Planning Application WA/32/21/PL
Land West of West Walberton Lane

House Type 3BH3

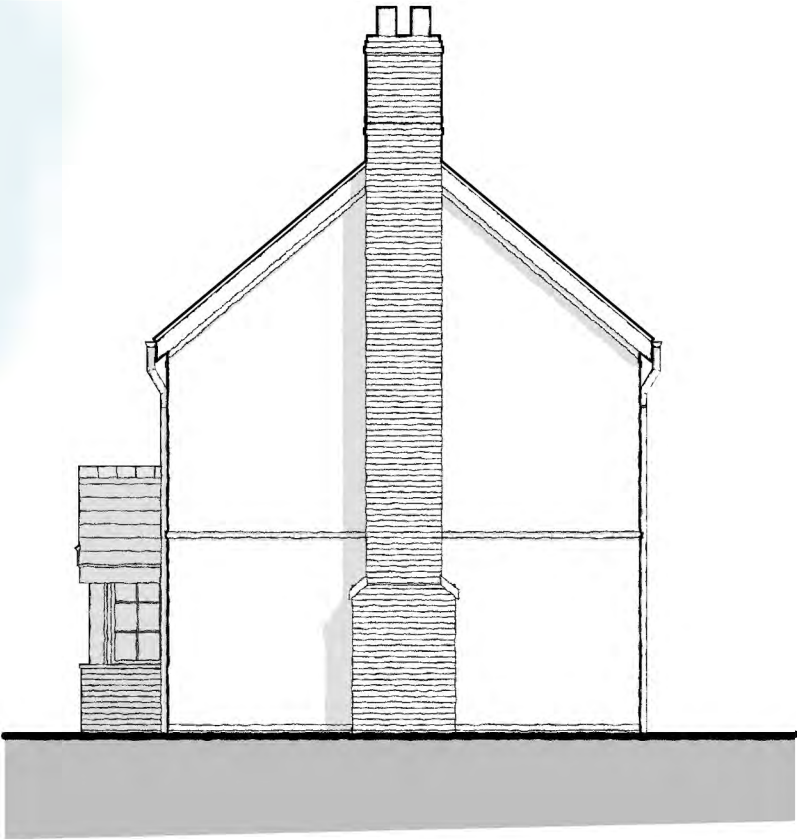
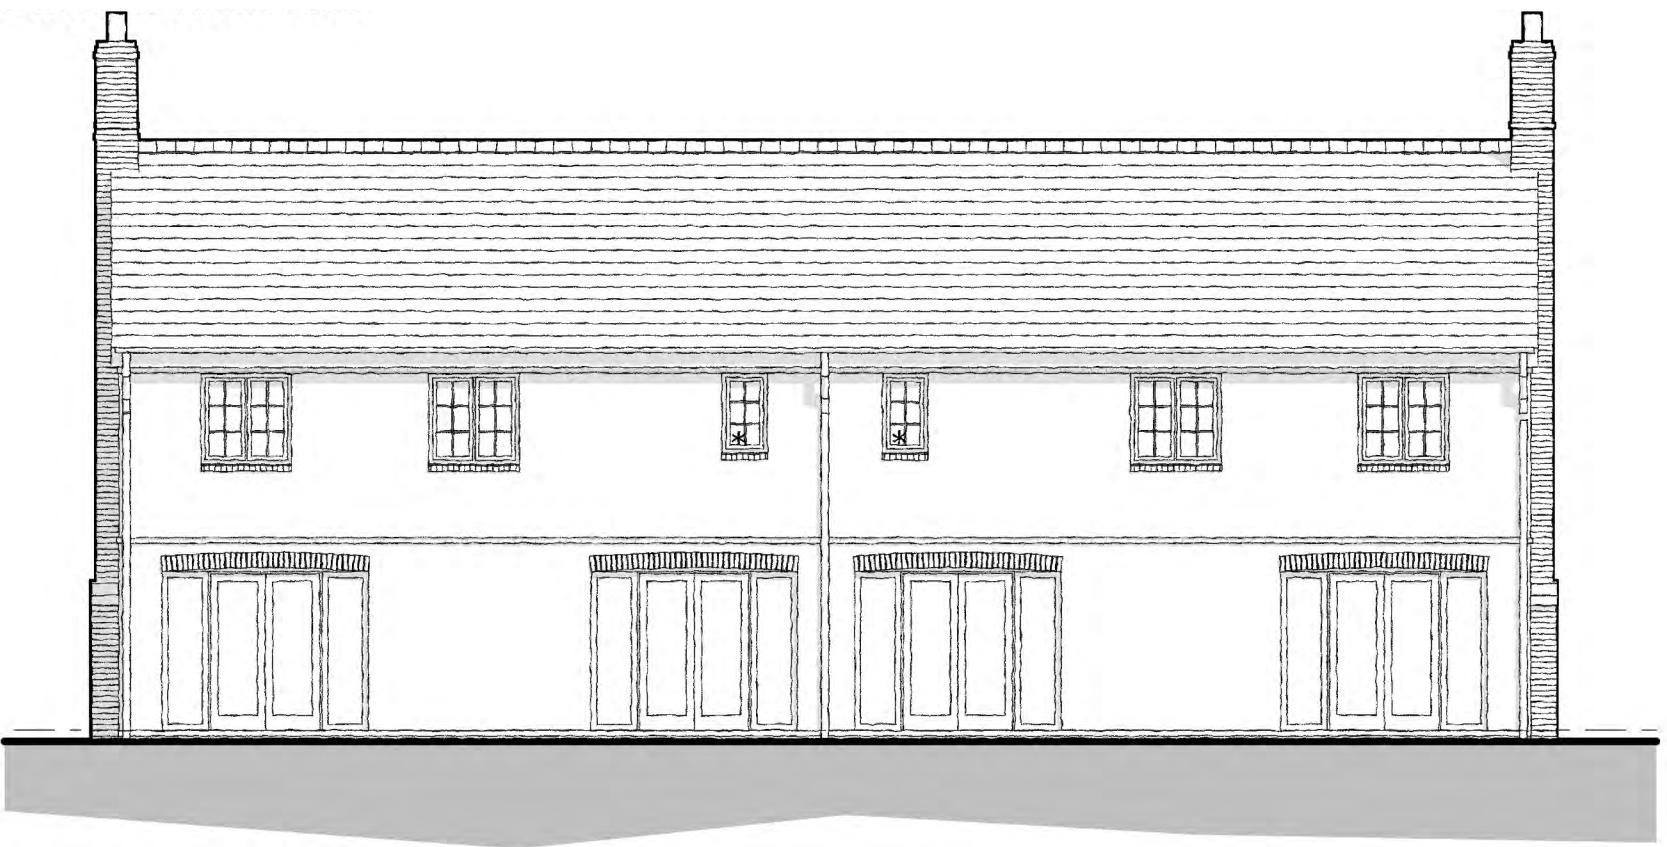
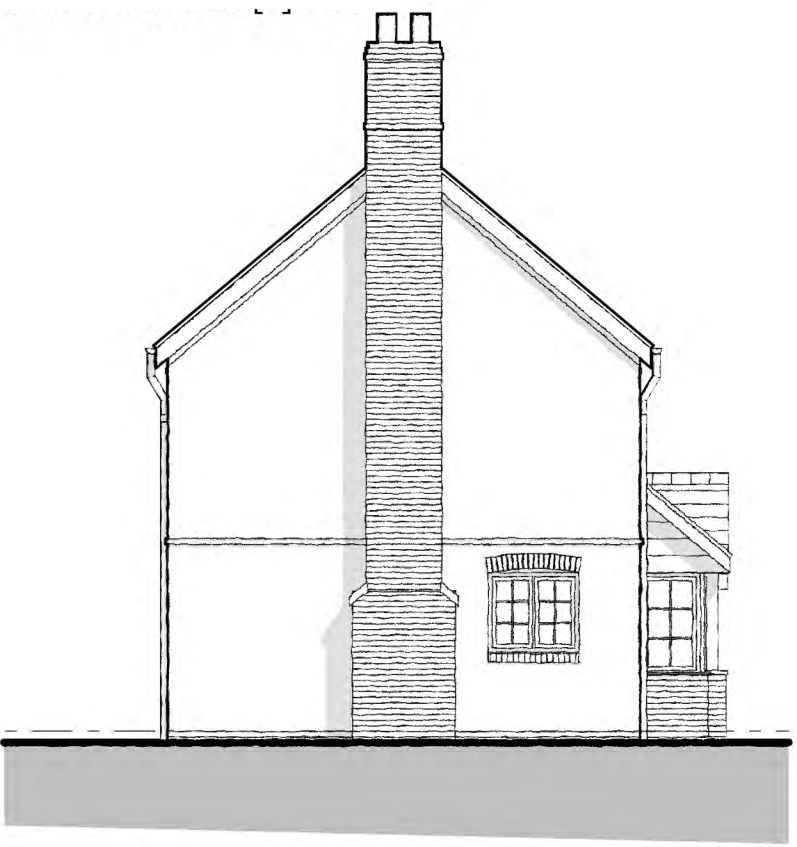
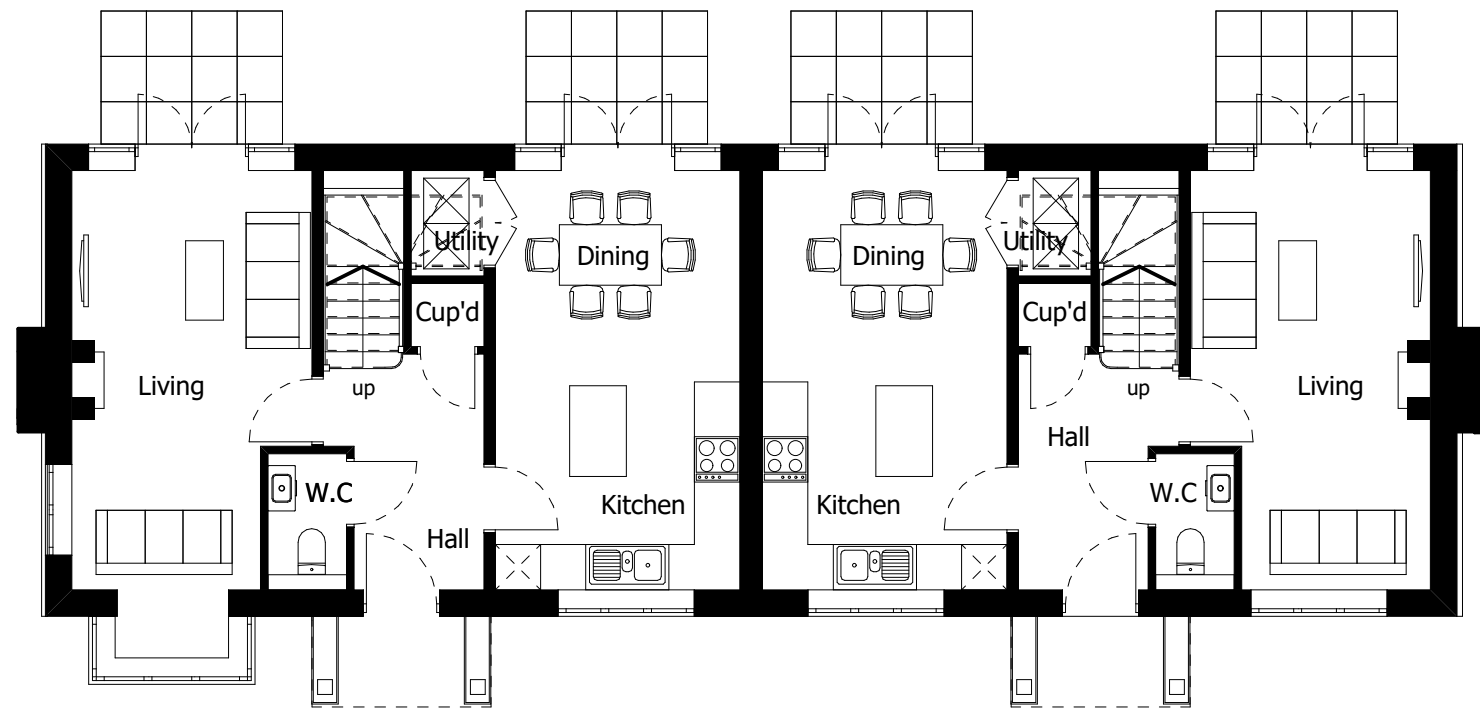
The design of the site buildings is completely out of character with the surrounding existing buildings. The use of bright-red tiles, red brick and timber facing is garish and clashes with the materials used elsewhere in the neighbourhood.
